Our ref: WA/2015/120746/02-L01
Your ref: 15/01012/OUT
Date: 26 November 2015

**Outline - development of up to 48,308sqm of employment floor space (class B1C, B2, B8 and ancillary B1A uses), the siting of buildings to the south of the site, servicing and circulation areas, vehicular and pedestrian access from Skimmingdish Lane and landscaping
Land North East of Skimmingdish Lane, Launton, Oxfordshire**

Environment Agency Position

**Concept drainage
plan**

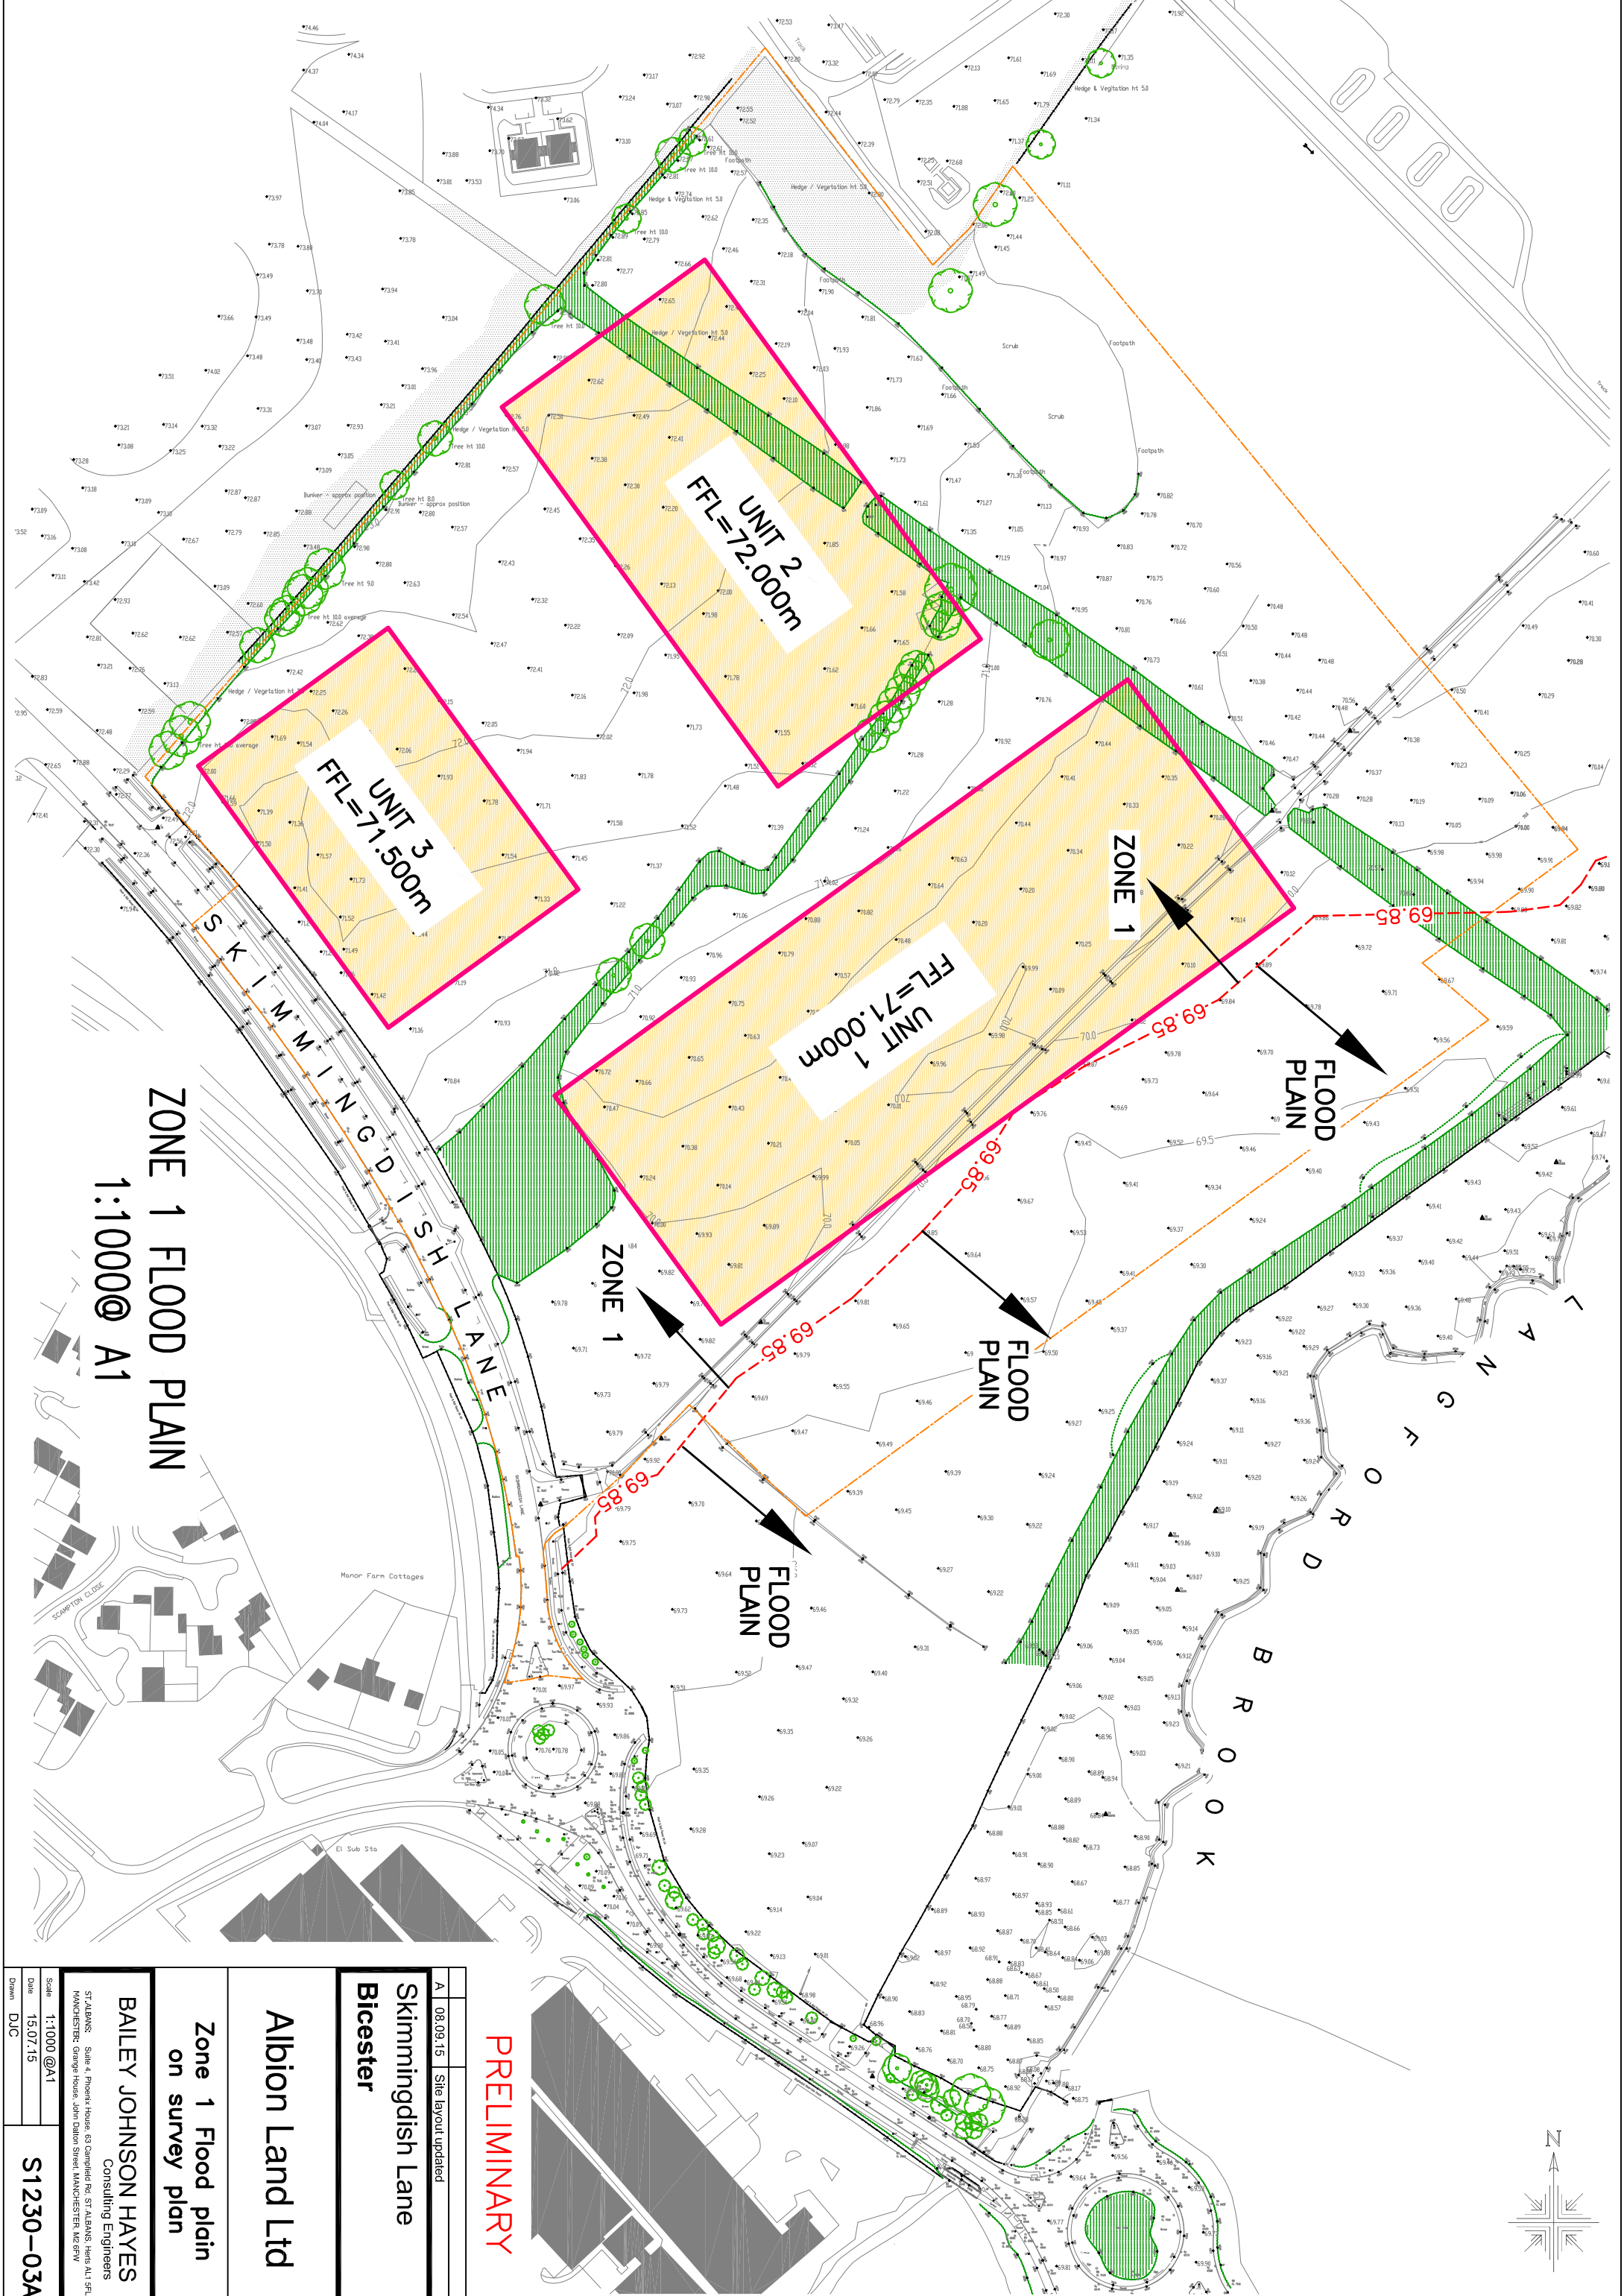
We would also expect to see detail on the outfall design from the three surface water drainage points, protecting against local scour of the watercourse.
